MEMORANDUM

SUBJECT: SF-23-004 – Saddlehorn Ranch Filing No. 3
Third Submittal

General / Letter of Intent/Final Plat

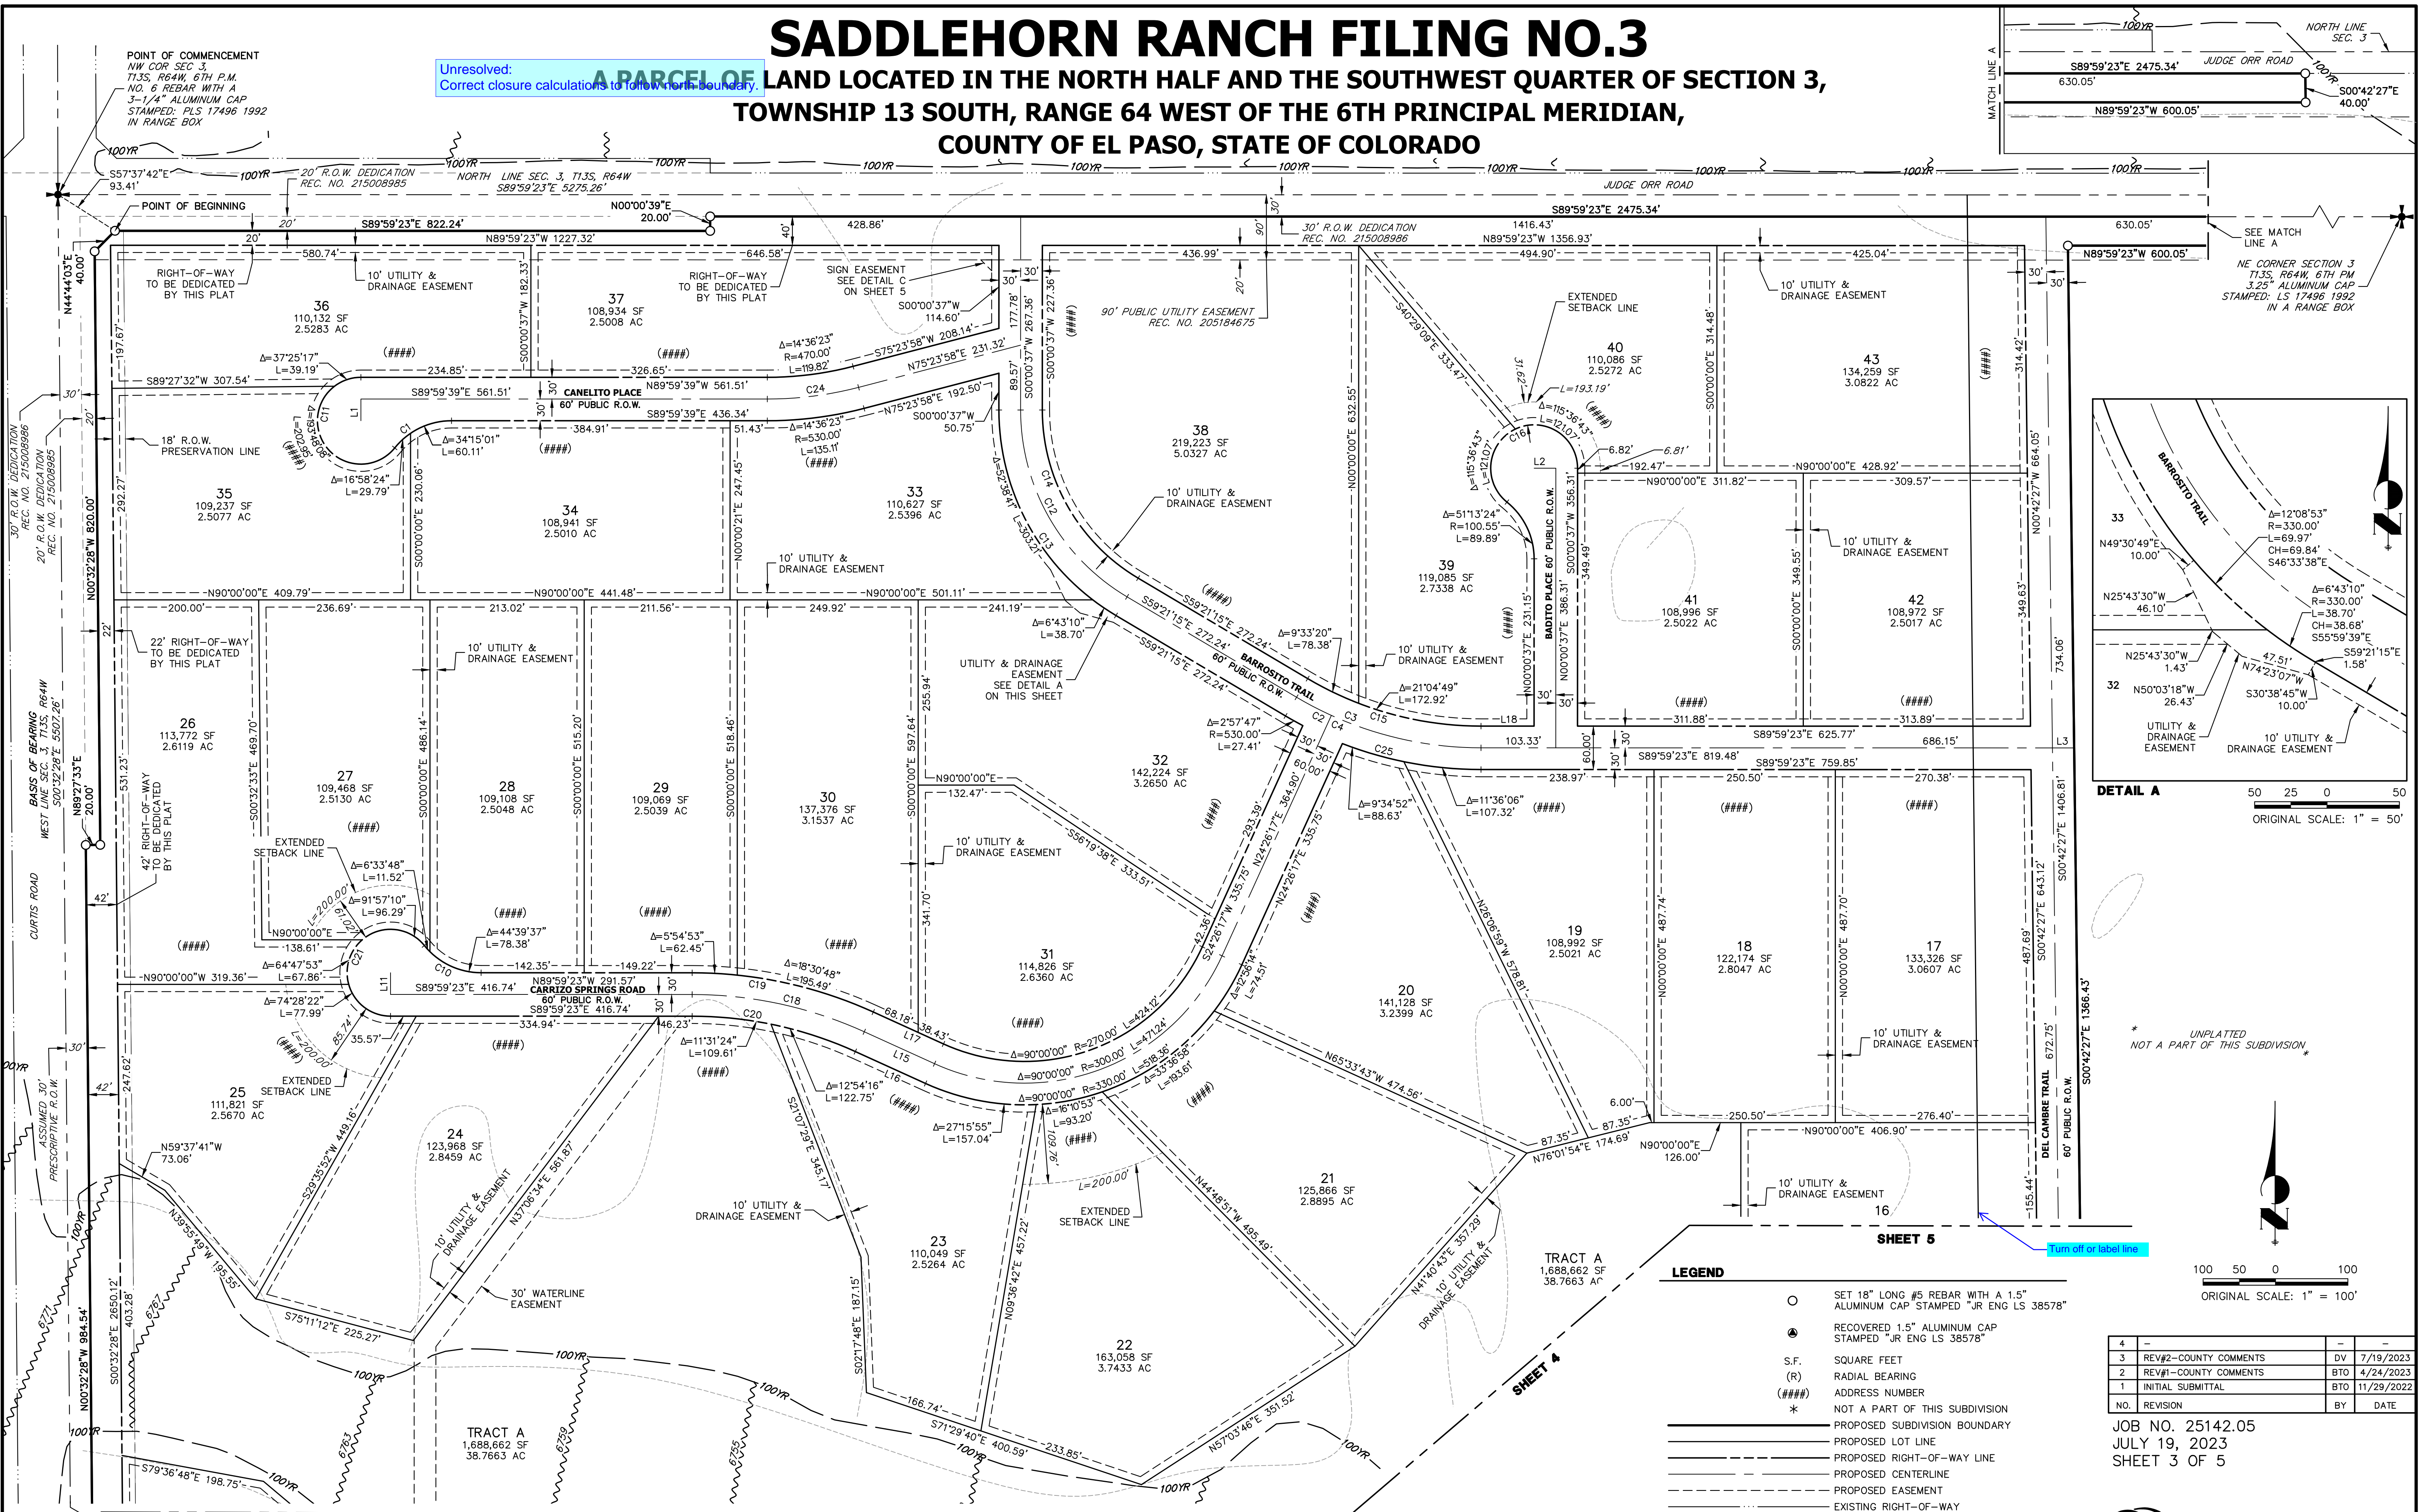
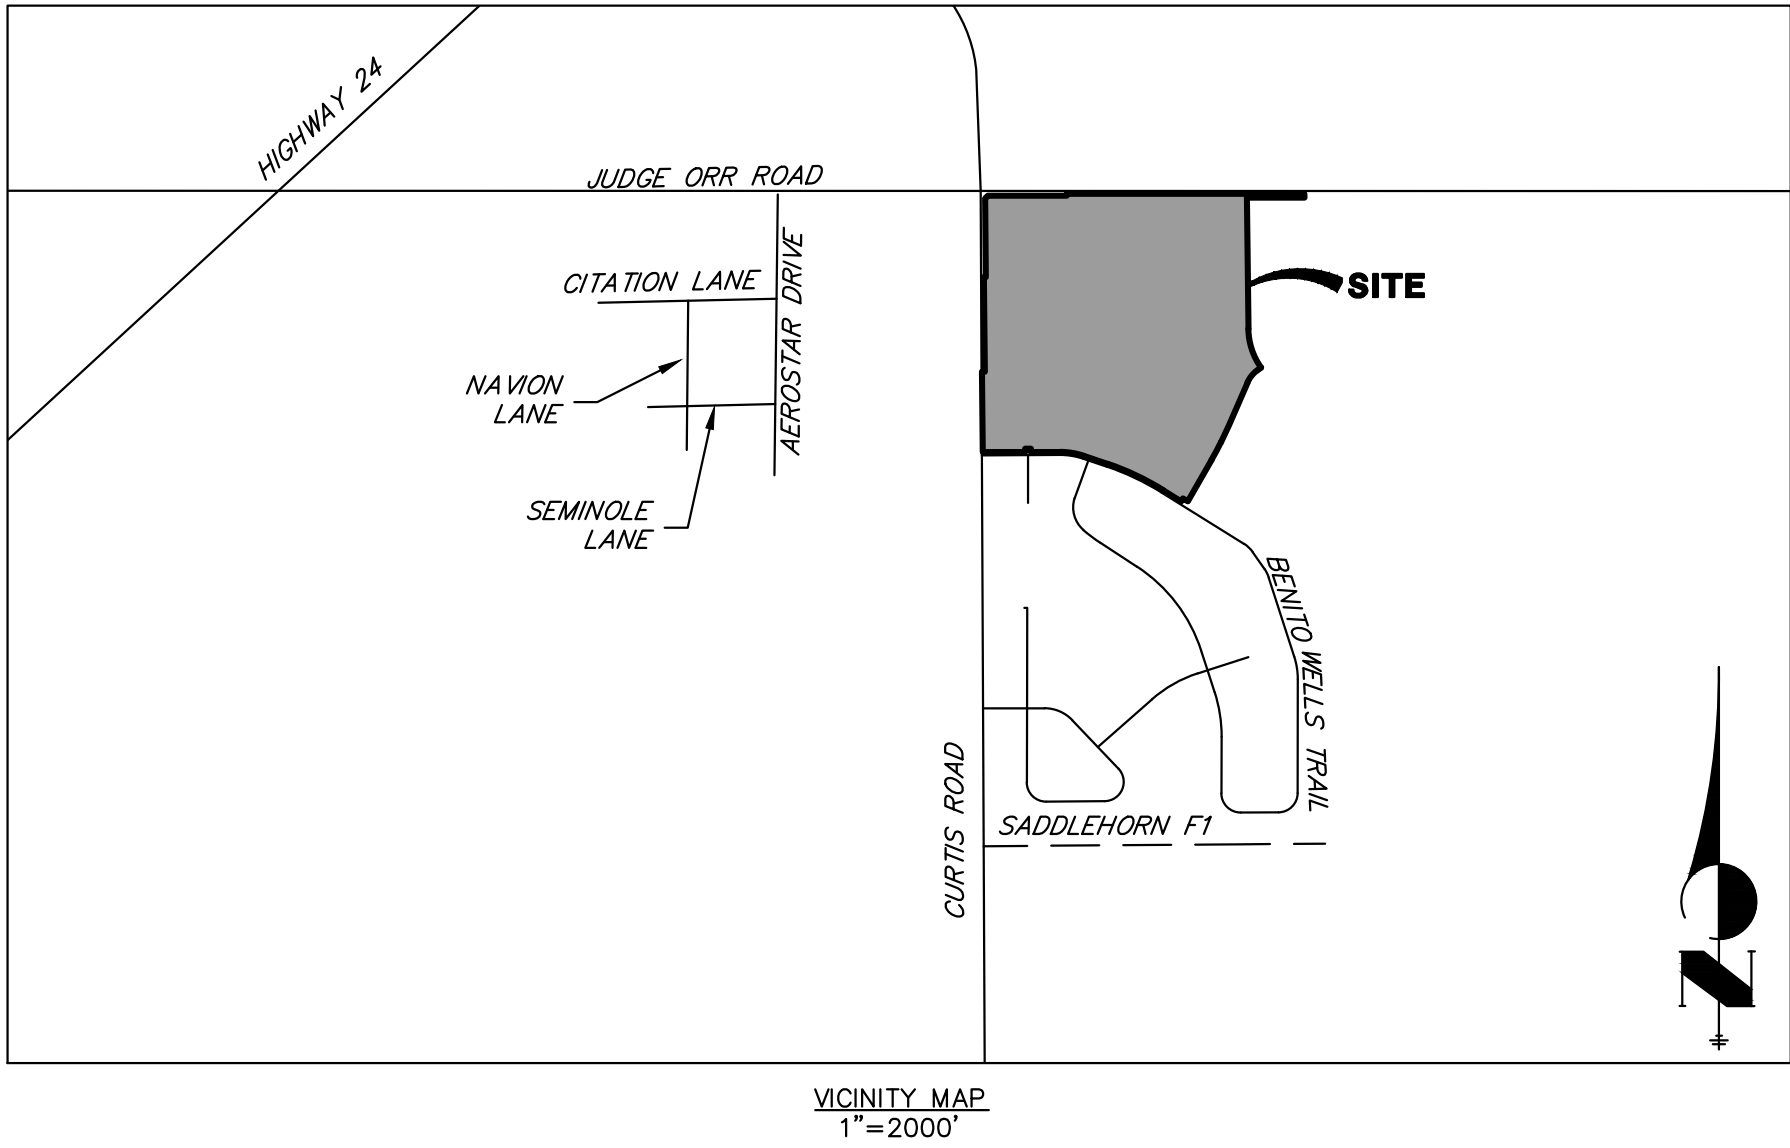
1. Resolved.
2. See Final Plat redlines. **See updated/remaining redlines.**
3. Legal Description and Closure sheets (from submittal 1, as it was not resubmitted) do not have the same project area. Please update so closure sheet and Legal Description match and update any other documents accordingly. **Unresolved.**
